**STAGE 1 SHEPHERDS BAY
RESIDENTIAL**

ACCESS REVIEW

Morris-Goding Accessibility Consulting

6 August 2012

B-02,UB - 03, LG - 09, LG - 16, LG - 03, GF - 09, GF - 26, GF - 03,
1-09, 1-28, 1-03,2-09, 2-26, 2-03, 3-03, 3-21, 4-03, 4-22,

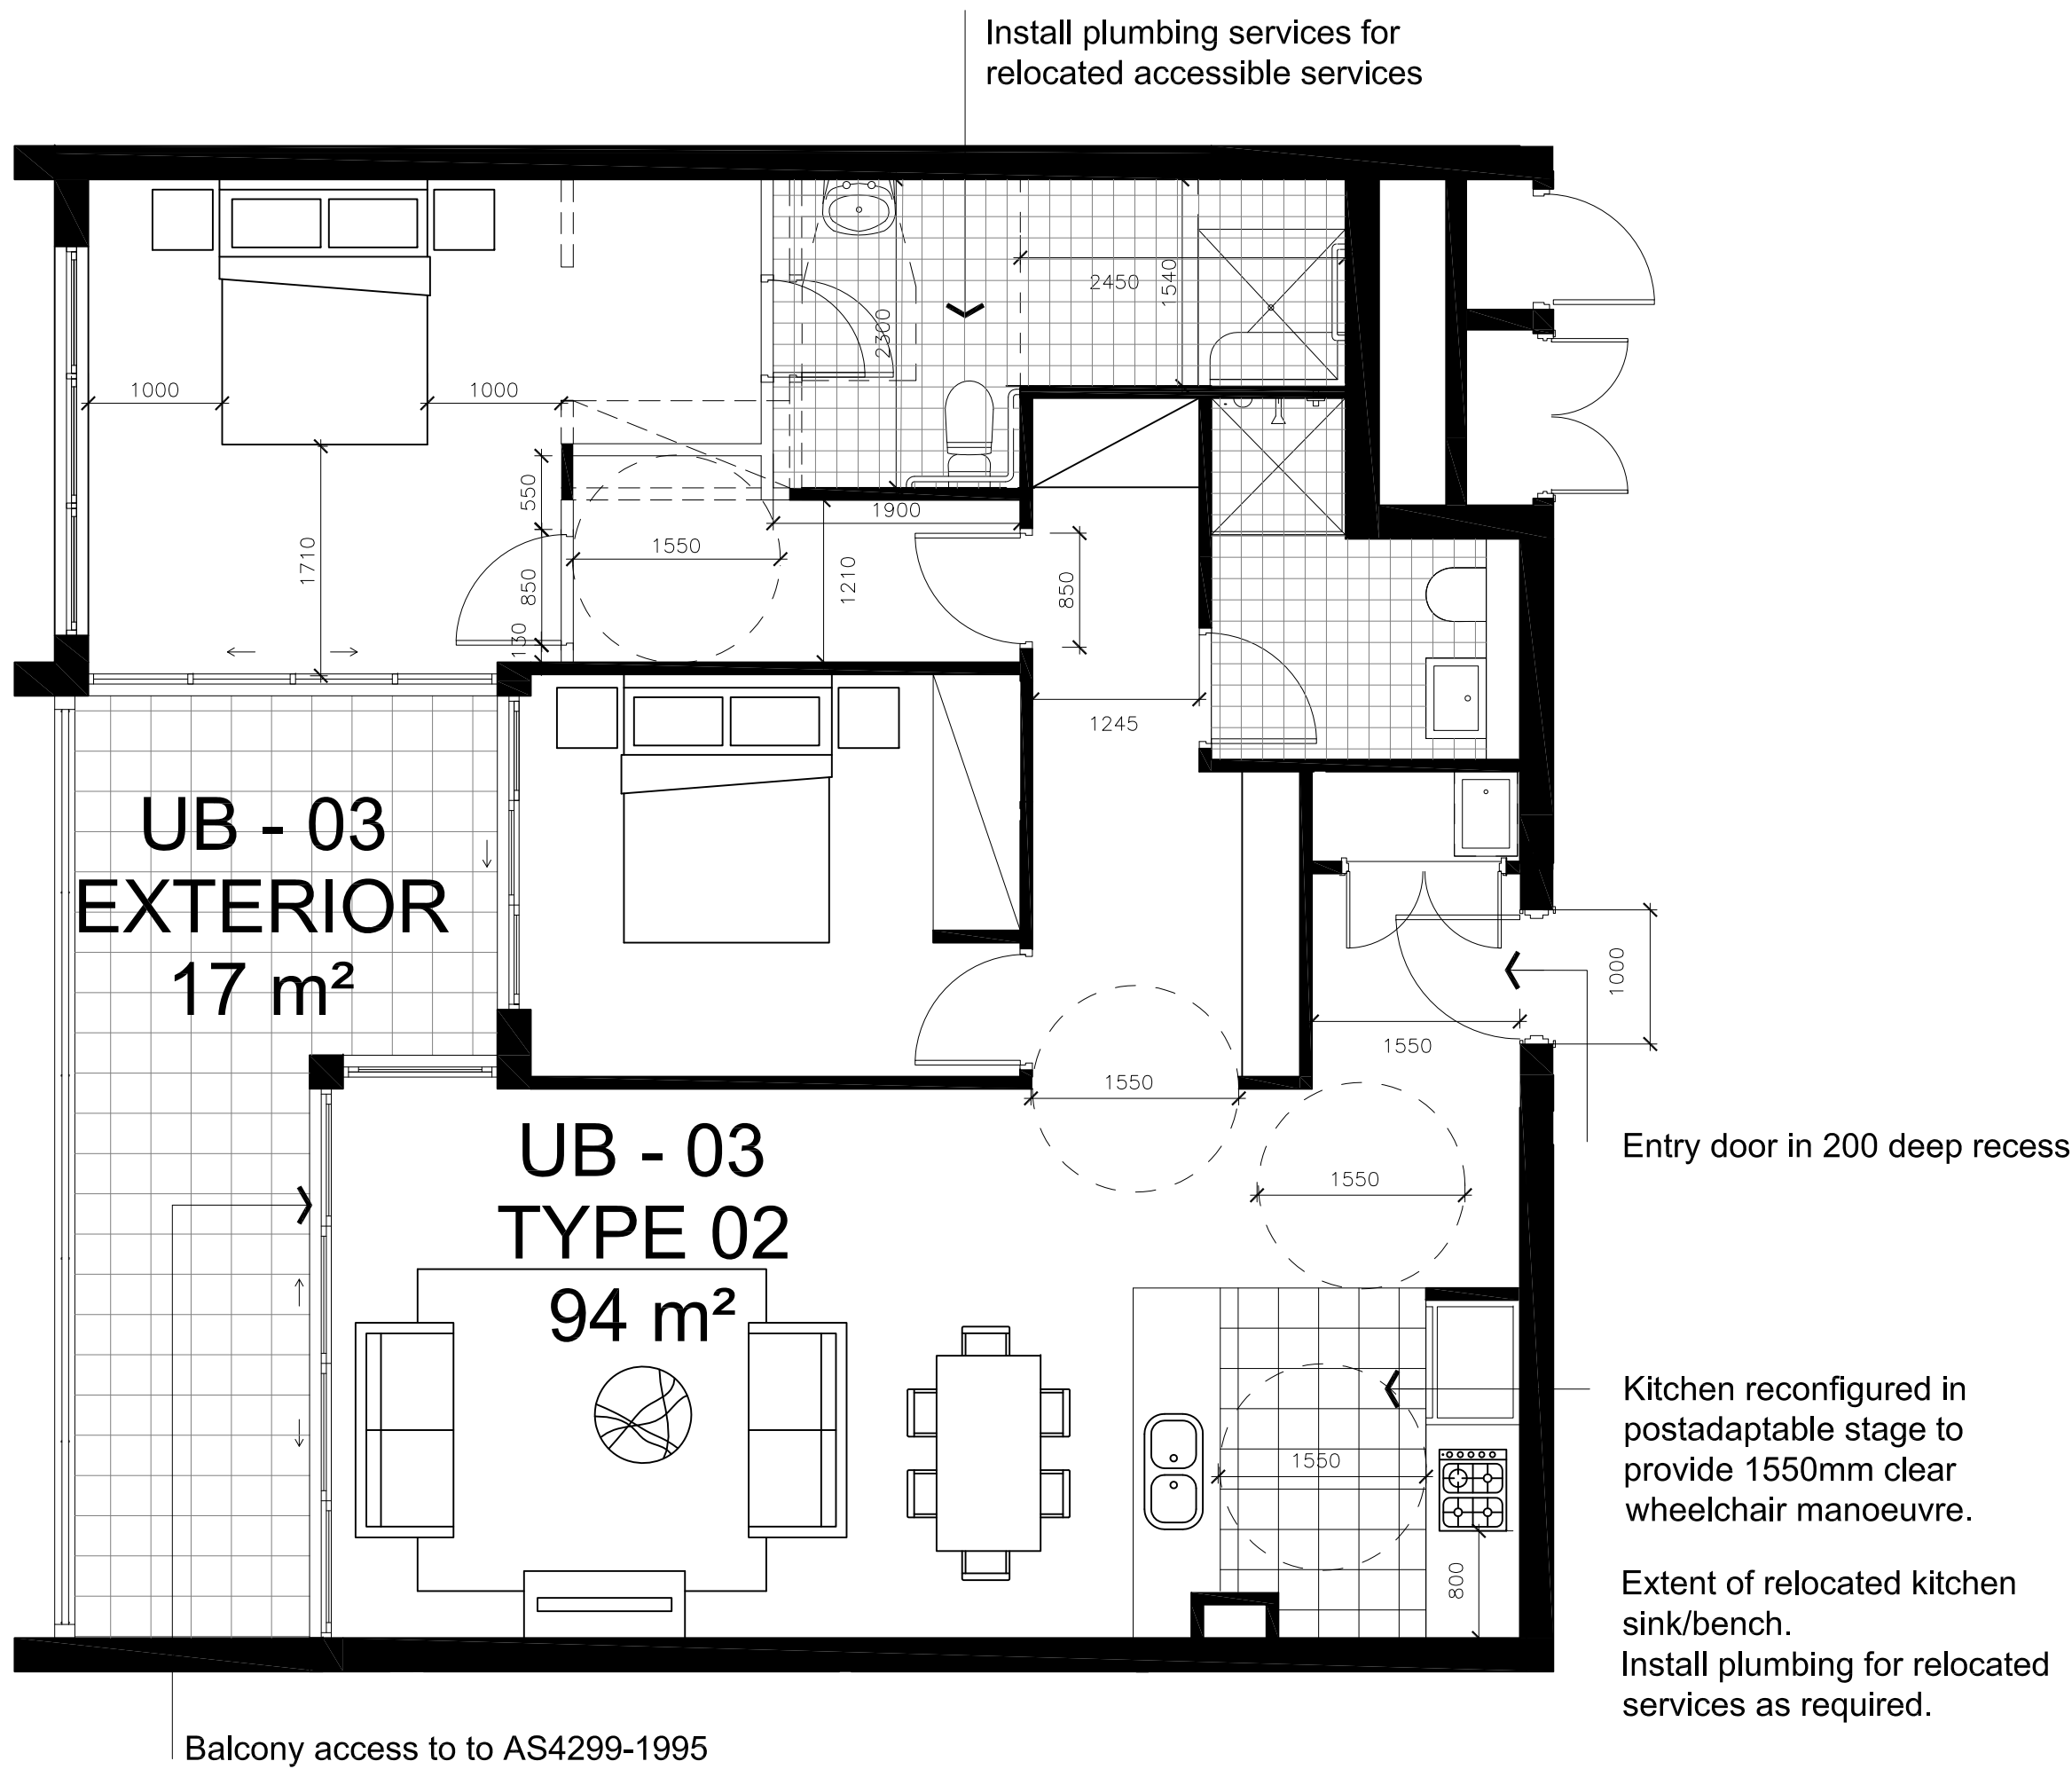
There is a 1550mm clearance between base cabinets of kitchen suitable in accordance with AS4299. There is an appropriate 800mm clearance adjacent to the cooktop and sink. There is a 190mm clearance adjacent the refrigerator. Ensure a suitable smaller workspace with a minimum 400mm clear width suitable in accordance with AS4299.

The corridor width in front of the bedroom door has suitable circulation for wheelchair side approach. The door currently has a 800mm clear width with a 140mm latch side clearance which will need modifications to ensure wheelchair circulation. The bedroom can achieve internal dimensions of 3600mm x 3600mm, outside the robe area compliant with AS4299.

The accessible ensuite has a 690mm clear width door, suitable circulation is achievable once the robe has been removed at post adaptation. Drawings are to show post-adaptation layouts with capped off services as required in pre-adaptation drawings to achieve the circulation requirements in compliance with AS1428.1. The en-suite will need to be enlarged to have suitable circulation areas compliant with AS1428.1:2009.

- (i) All internal doors require a minimum 820mm clear width in accordance with AS4299. Doors shall have a 510mm latch side clearance suitable for wheelchair accessibility.
- (ii) The laundry requires a minimum 1550mm diameter turning area in front of the appliances suitable for wheelchair circulation in accordance with AS1428.1:2009.
- (iii) Bathroom (shower, toilet, wash basin) to comply with circulation area requirements of AS1428.1, that is provide an area of 2300mm x 1900mm around the pan. The wash basin should sit outside this area, and if needed only encroach into this area by 100mm (max). In general, the bathroom should be 2750mm x 2300mm (min).

UB - 10, LG - 22, GF - 32

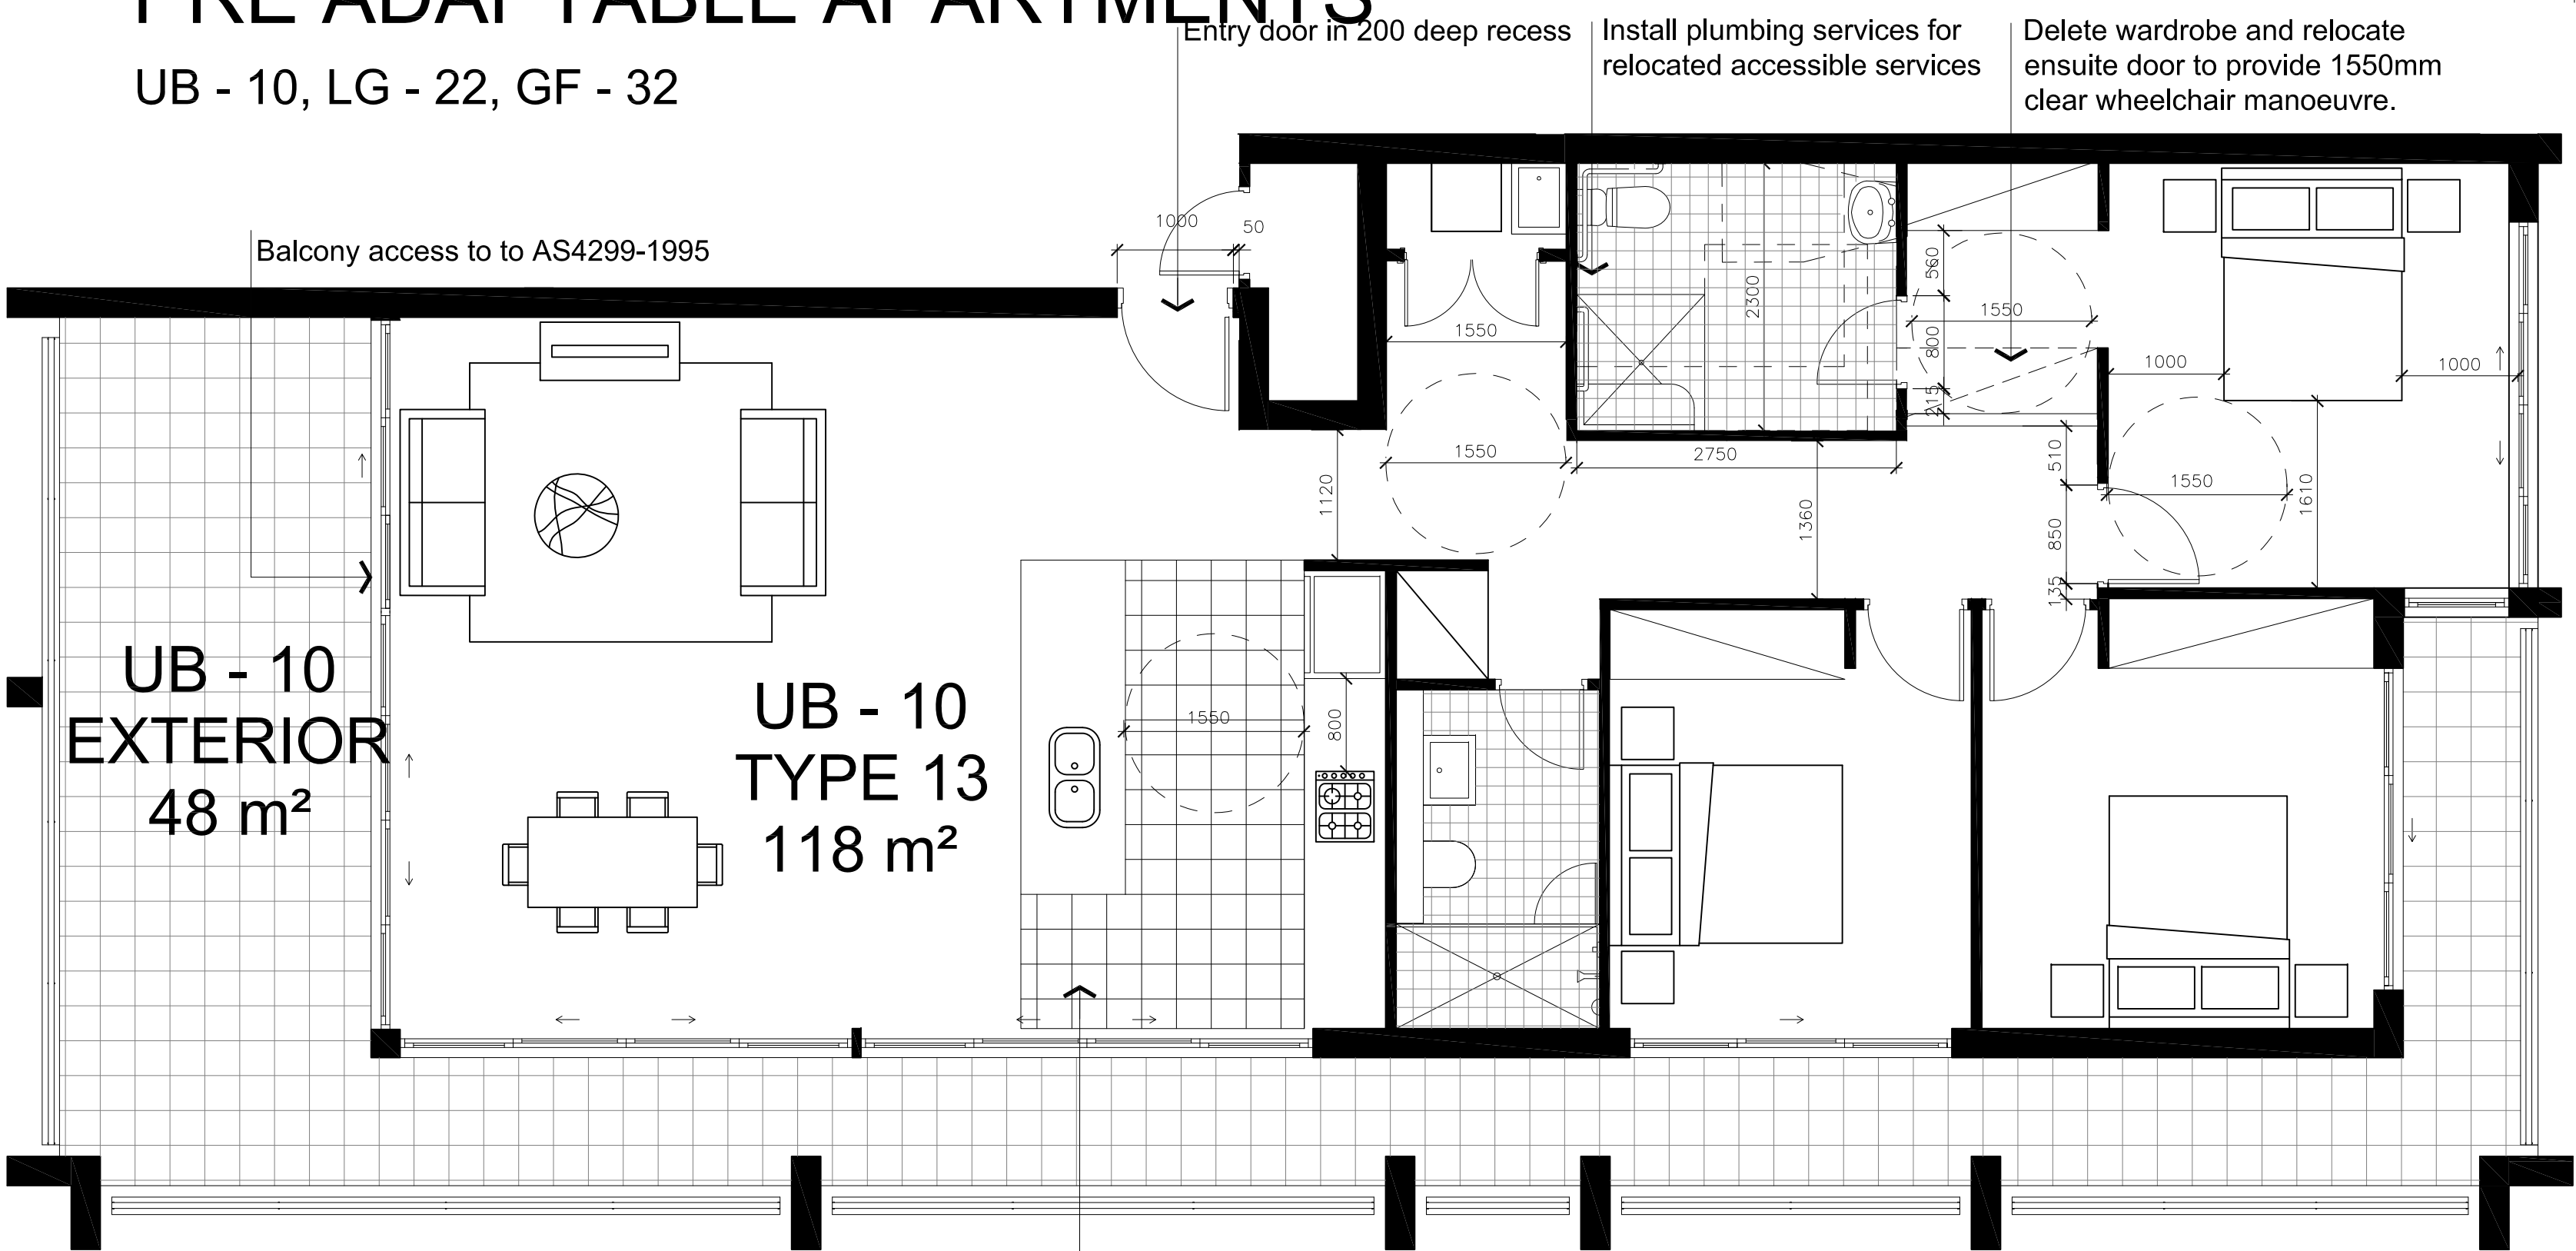
The corridor width in front of the bedroom door appears to be suitable. The hinged entry door has an 800mm clear width with a 460mm clear width. The bedroom has suitable circulation around the bed compliant with AS4299.

The accessible ensuite has a 680mm clear width door with a 345mm latch side clearance in accordance with AS1428.1:2009. The drawings indicate that the door is relocated at post-adaptation stage which will require retiling and waterproofing. The bathroom has internal dimensions of 2205mm x 2680mm which will need to be modified to ensure suitable circulation around the pan, shower and basin. Drawings are to show post-adaptation layouts with capped off services as required in pre-adaptation drawings to achieve the circulation requirements in compliance with AS1428.1:2009.

There is a 1550mm clearance between base cabinets of kitchen. Floor to be tiled pre-adaptation to allow for relocated kitchen bench. There is sufficient work bench space to allow for a compliant kitchen. There is an appropriate 800mm workbench adjacent the cooktop, sink and refrigerator.

- (i) All internal doors require a minimum 820mm clear width in accordance with AS4299. Doors shall have a 510mm latch side clearance suitable for wheelchair accessibility.
- (ii) Bathroom (shower, toilet, wash basin) to comply with circulation area requirements of AS1428.1, that is provide an area of 2300mm x 1900mm around the pan. The wash basin should sit outside this area, and if needed only encroach into this area by 100mm (max). The shower seat currently encroaches into this area. In general, the bathroom should be 2750mm x 2300mm (min).
